Application for Approval of Details Reserved by Condition

Discharge of details reserved by conditions 8 (substation design), 9 (roof-level photovoltaic panels), 12 (pumping station design) and 15 (water safety measures) of previous Reserved Matters approval 2025/92242 (including consideration of appearance, scale and landscaping) for erection of 80 dwellings, pursuant to Section 73 approval 2025/90105 pursuant to previous outline permission 2022/91735

Land off Hermitage Park, Lepton, Huddersfield, HD8 0JU

Application Number: 2026/90913

Drawing No. 1223 - 114	Rev. E
------------------------	--------

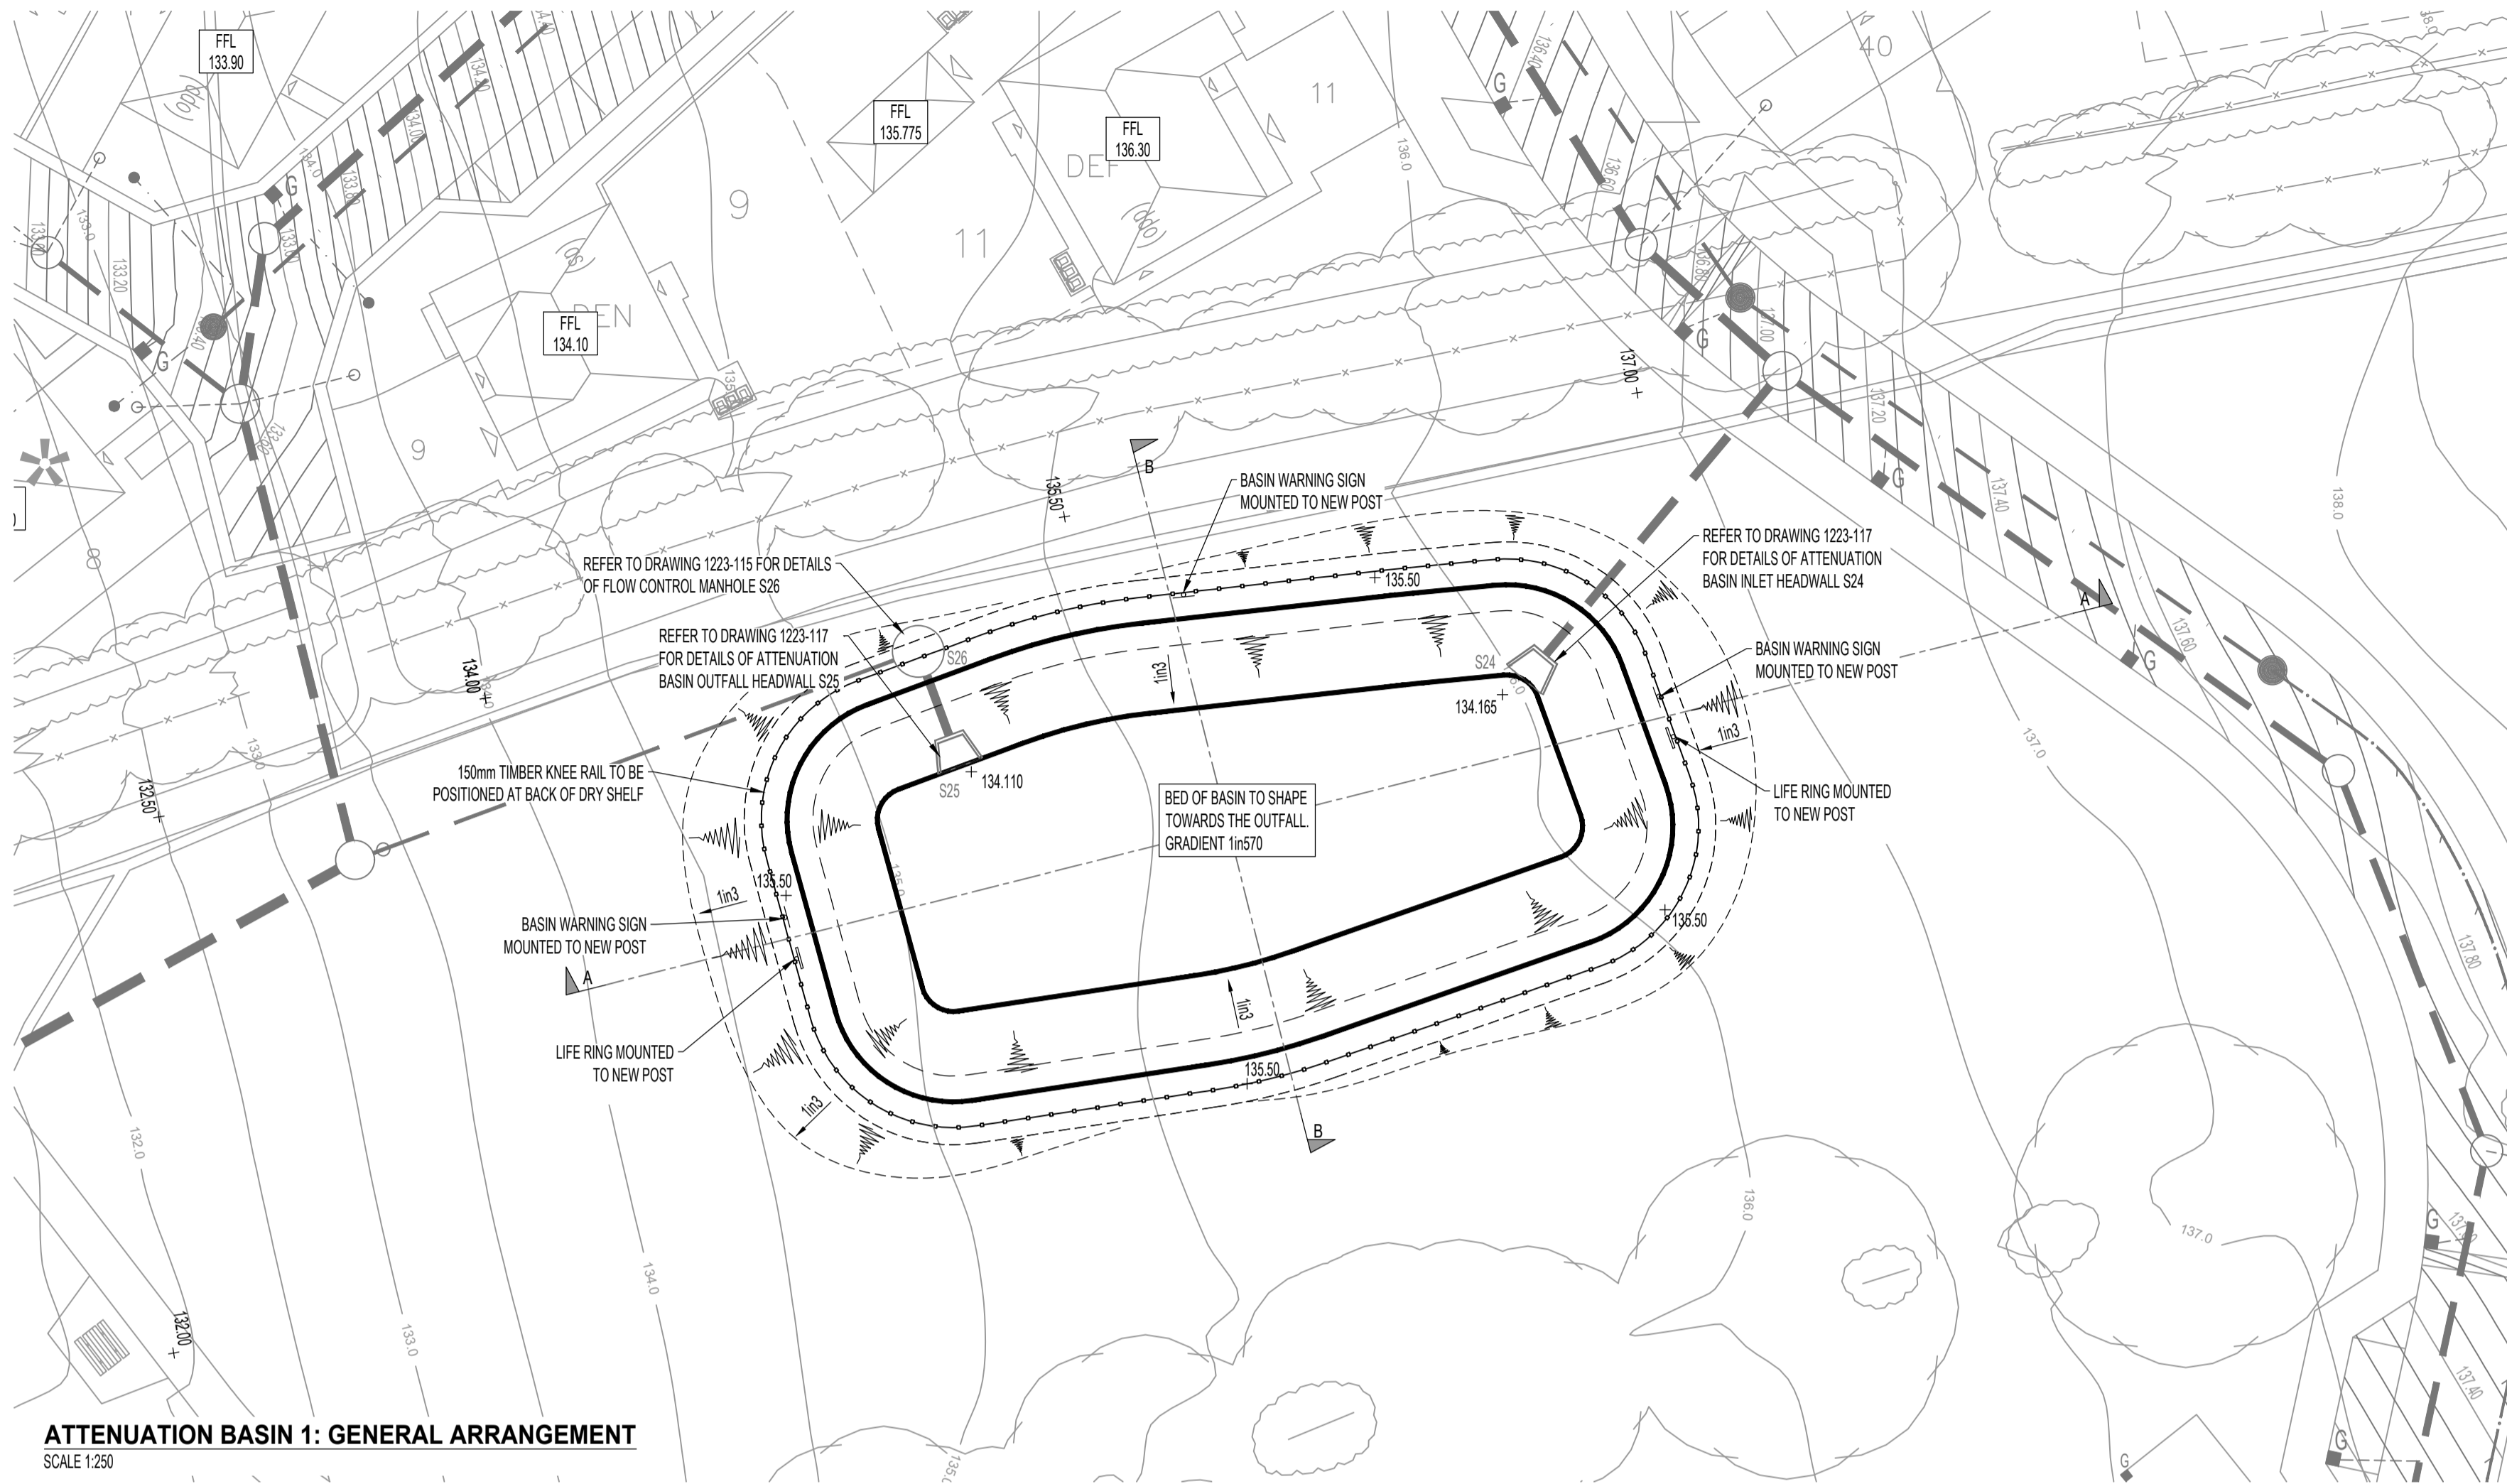
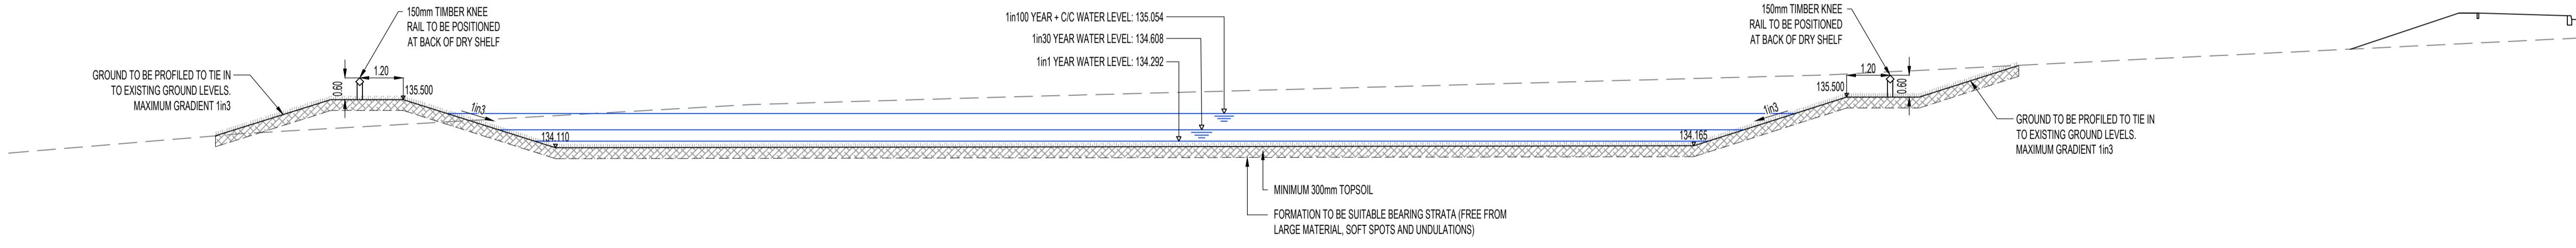
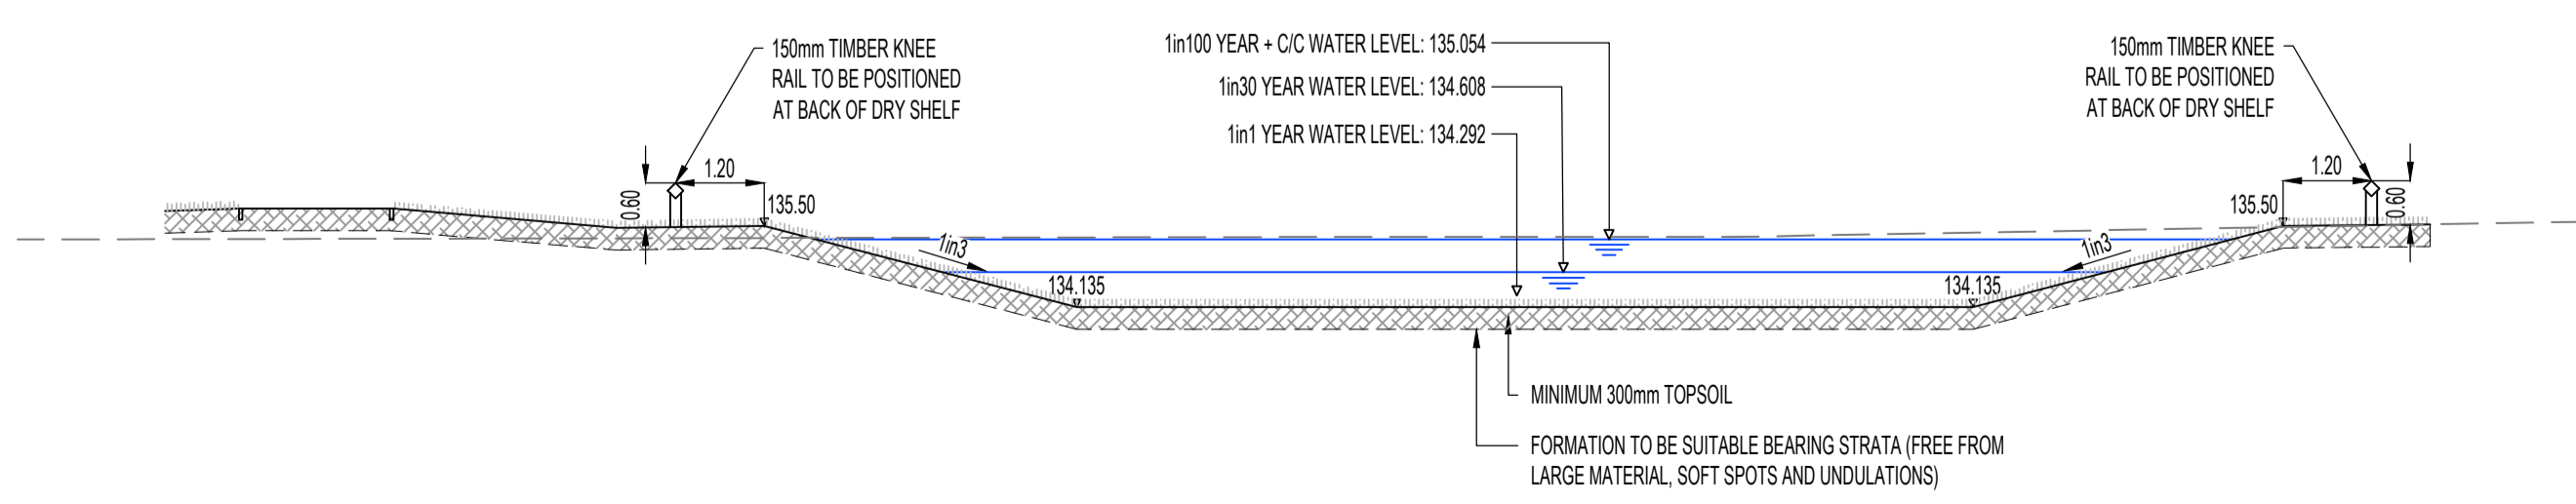
Condition 15 (water safety measures) – You initially submitted drawings 1223-114 rev E and 115 rev E pursuant to condition 15. You later submitted drawing 260515-ATPL (showing an access track to the westernmost basin) on 04/06/2026, and drawing SD13.ENG.01.06 (showing details of the Grasscrete surface proposed for the access track) on 23/06/2026. While the submitted details of the water safety measures (including those of the access track) are considered acceptable, as advised on 09/06/2026 and in the interests of consistency, the basin drawings need to be updated to correspond with those that have more recently been submitted under Discharge of Conditions application 2025/93057. Drawing 1223-115 should also be updated to show the access track. Condition 15 will be considered further once updated drawings have been submitted.

Foul Pump Station Elevations
1.2m Bow Top Fence Detail

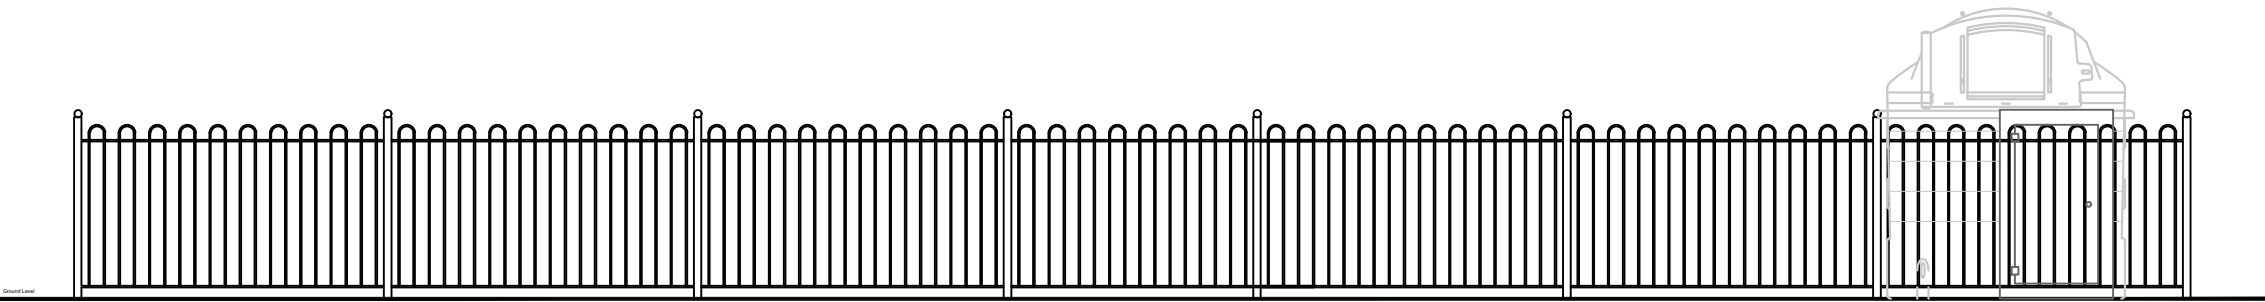
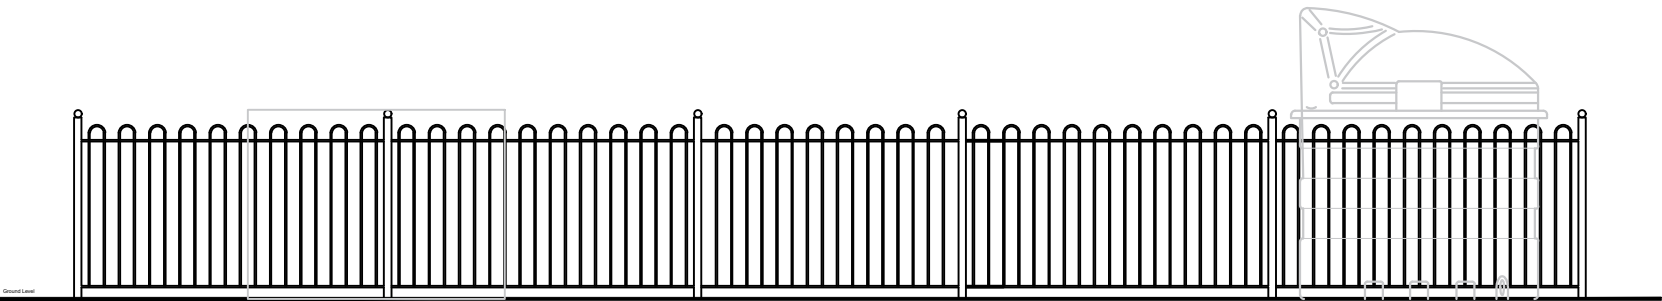
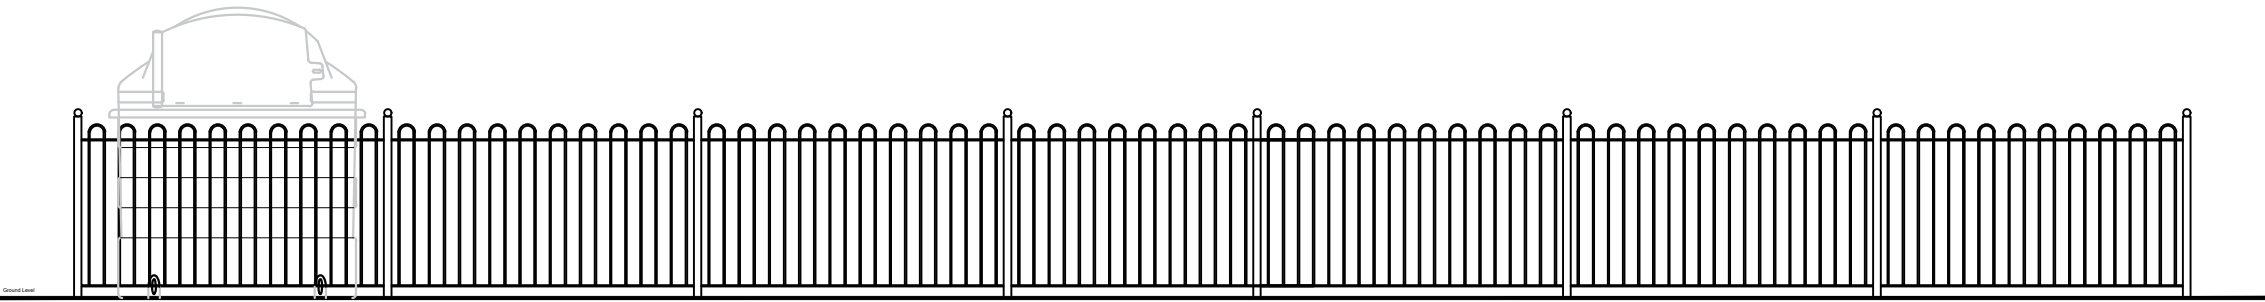
Condition 12 (pumping station design) – You initially submitted drawings PS-01 and 5728-31559-004 rev B pursuant to condition 12. These included details that were unacceptable or unclear. On 22/05/2026 you advised that a 1.2m vertical railing could be proposed around the pumping station. As advised on 09/06/2026, such a boundary treatment would be considered acceptable, however updated drawings would need to be submitted, and the other comments made on 18/05/2026 would need addressing. Condition 12 will be considered further once updated drawings have been submitted.
